Recommendation Report for Planning Permission for Works or Extension to a Dwelling

REF NO: BR/293/21/HH

LOCATION: 73 Nyewood Lane
Bognor Regis
PO21 2SD

PROPOSAL: Two storey side and rear extension, rebuilding of existing conservatory and demolition of existing garage.

Ground Floor
Plans

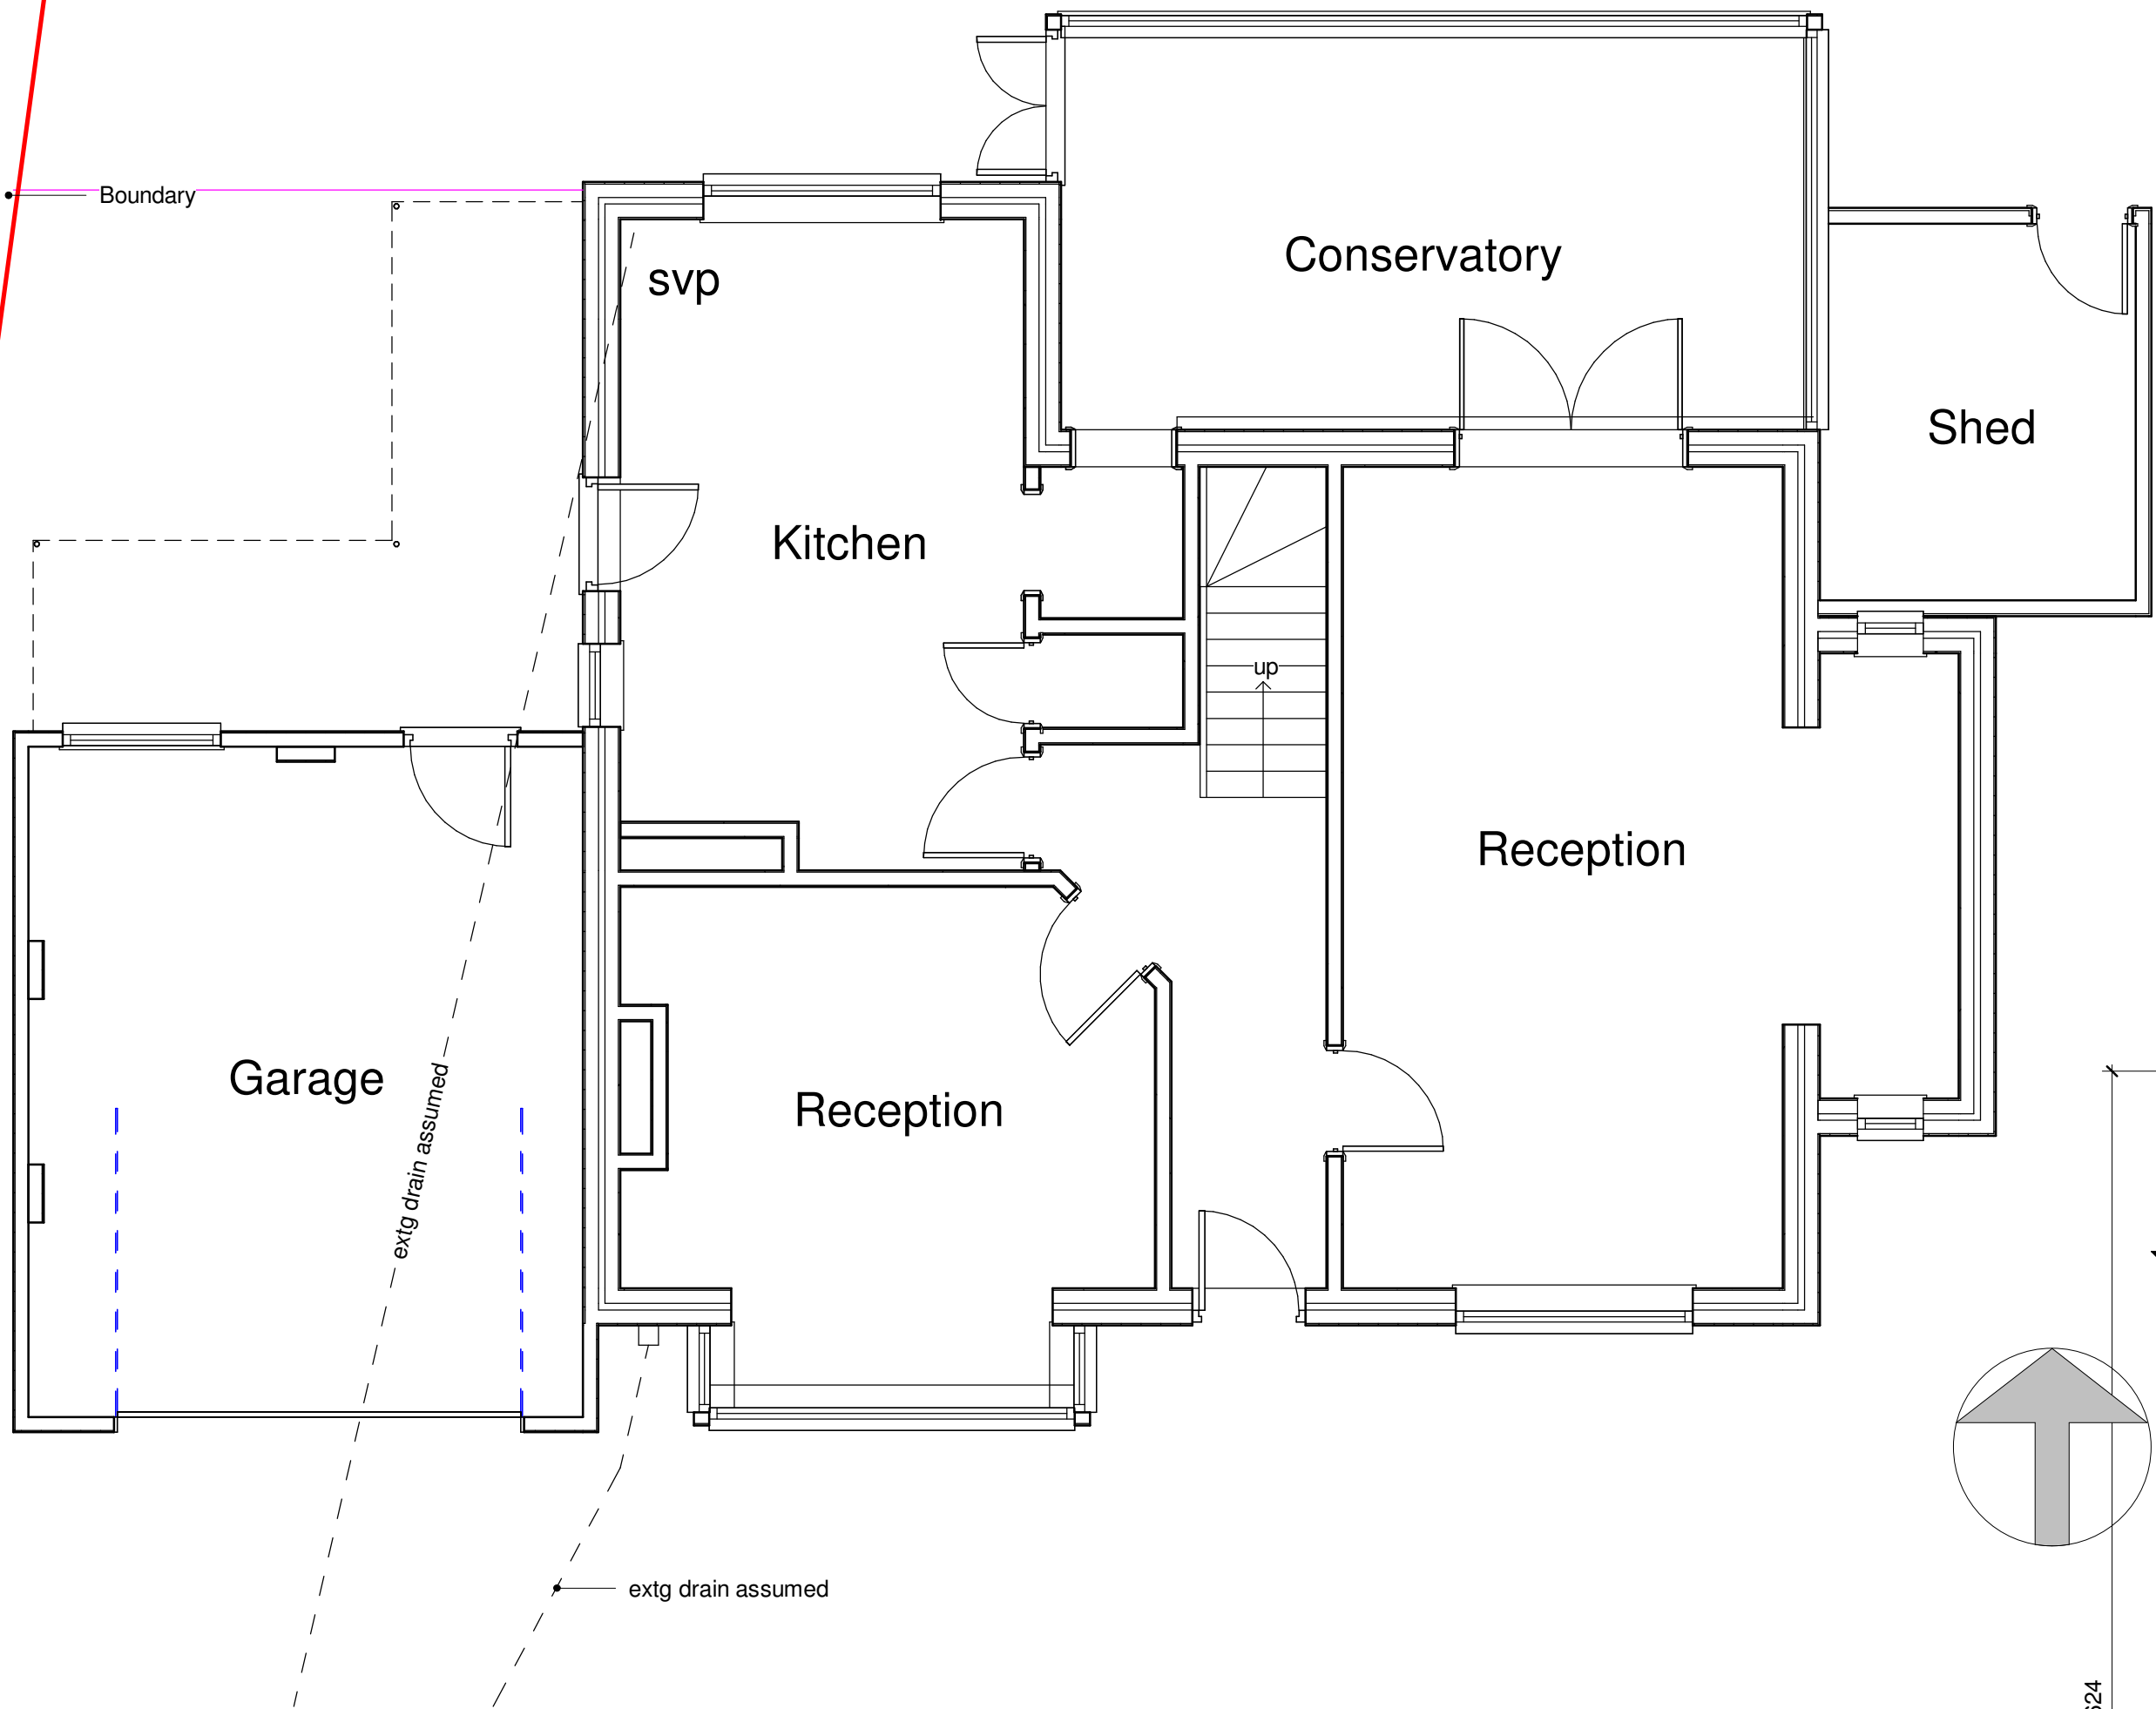
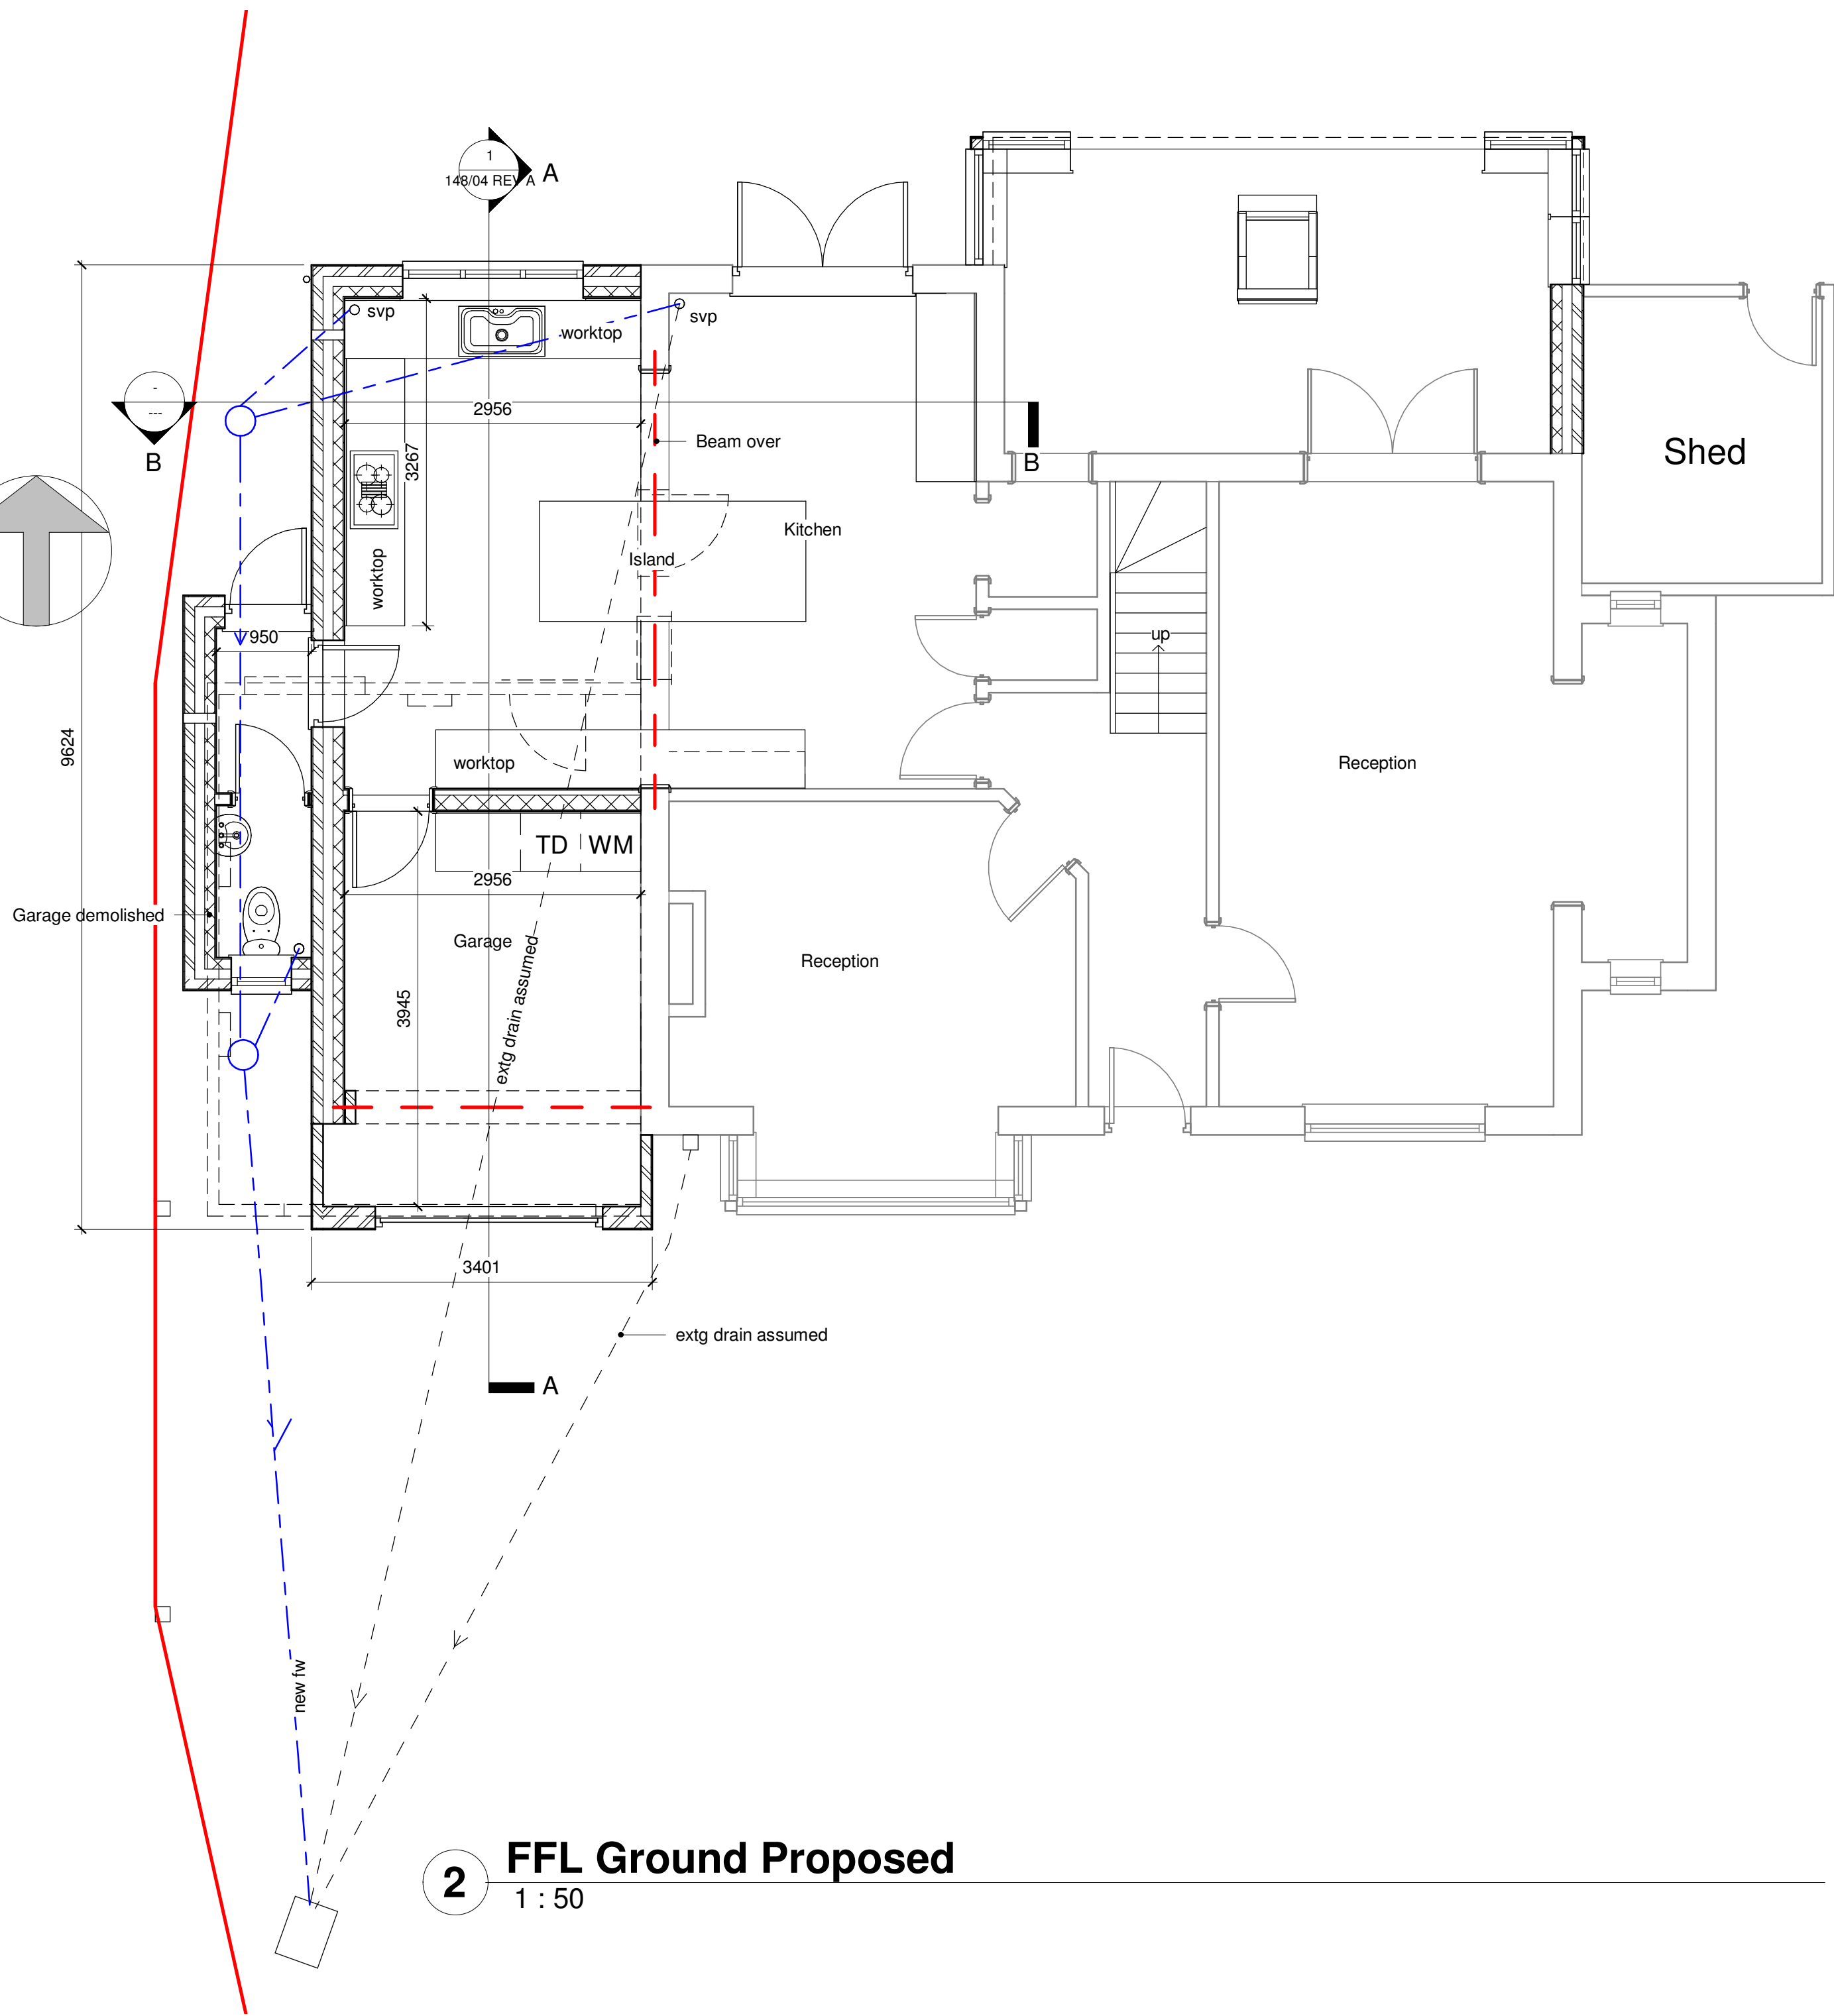
There will be a lean to roof to the front of the garage which is located to the ground floor of the extension, although this extends largely in line with the principal elevation of the property. There is also a modest single storey addition to the side elevation which is appropriate in scale meeting with the boundary to the south.

There is an existing conservatory which will be rebuilt. This extends slightly beyond the rear of the two storey addition however retains its existing footprint and height and its reconstruction will not result in
